31 Fore Street - Section 14-430

Ann Machado <amachado@portlandmaine.gov> Wed, Mar 16, 2016 at 10:14 AM
To: Jean Fraser <jf@portlandmaine.gov>

In the R-6 Residential Zone, section 14-139 states that the maximum allowable height for principal structures is 45 feet. Section 14-430(a) allows enclosed structures that house stairs to exceed the 45 foot maximum height restriction. The area of the enclosed stair structure should be the minimum required to meet the building and life safety codes. It should not contain habitable space.

ELEVATIONS

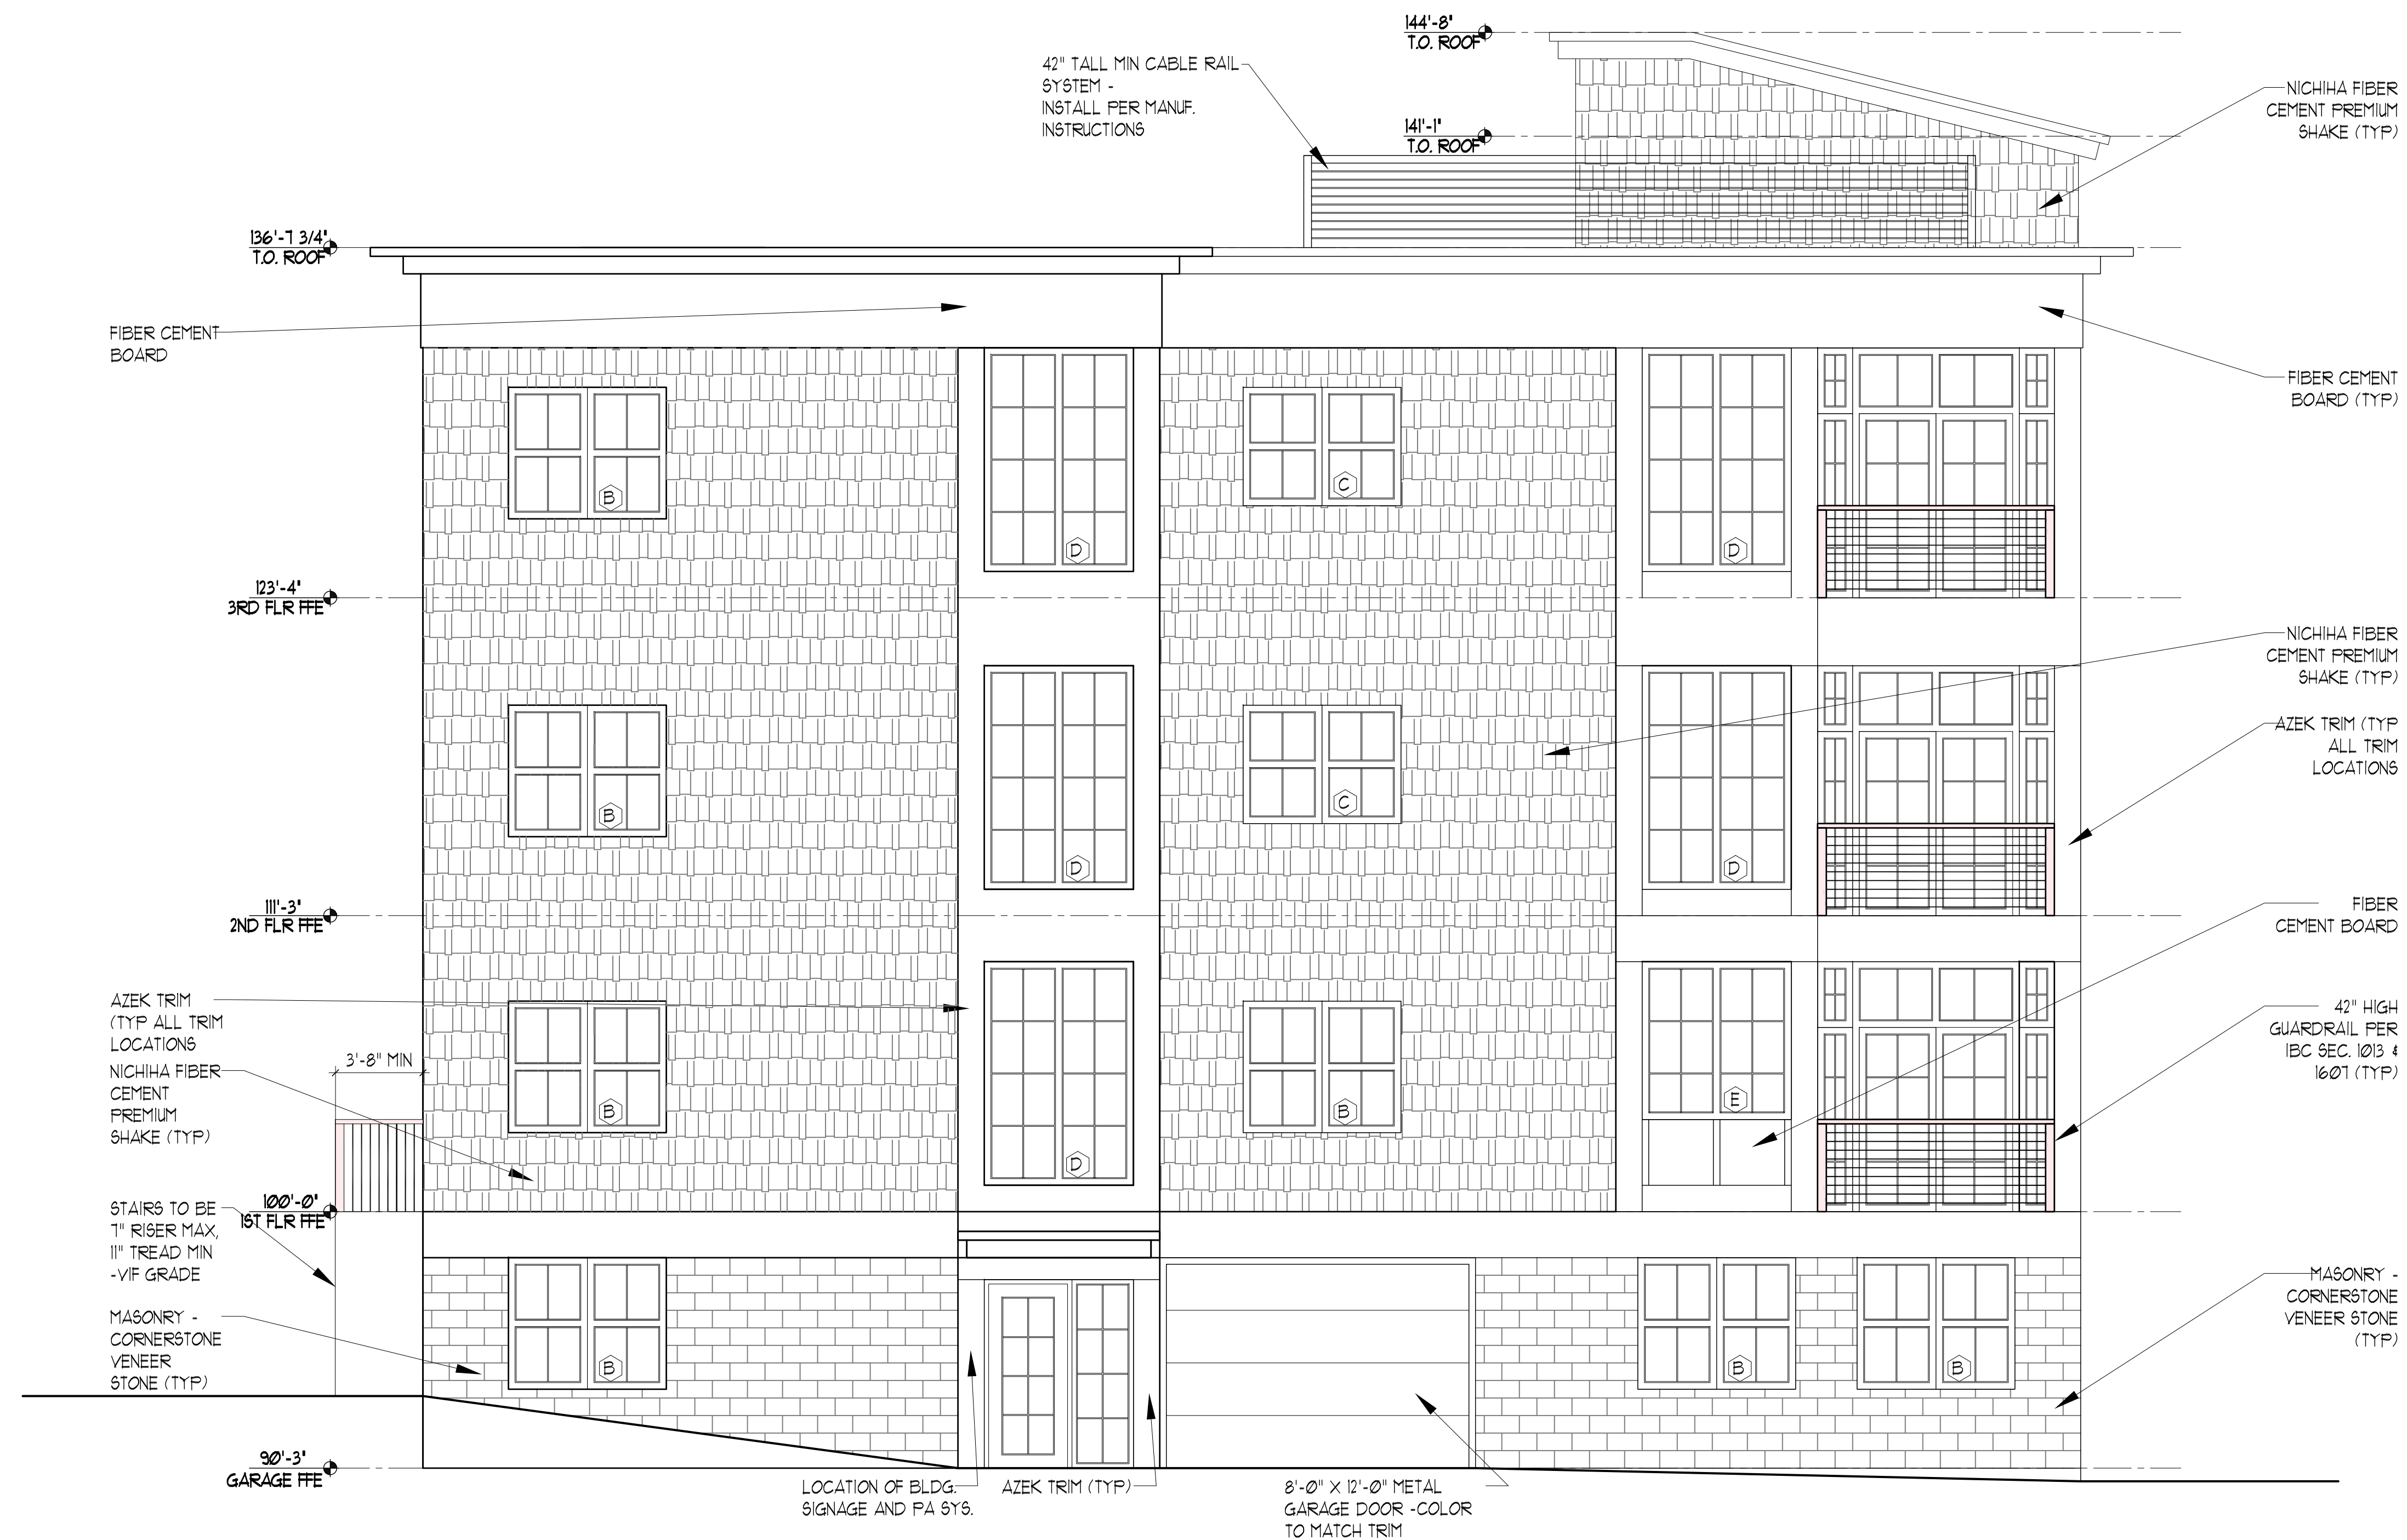
Section 14-139 also requires structure setbacks for "portions of a structure above 35 feet". Using section 14-430(a), enclosed structures that house stairs do not have to meet the structure setbacks and can be above 35 feet.
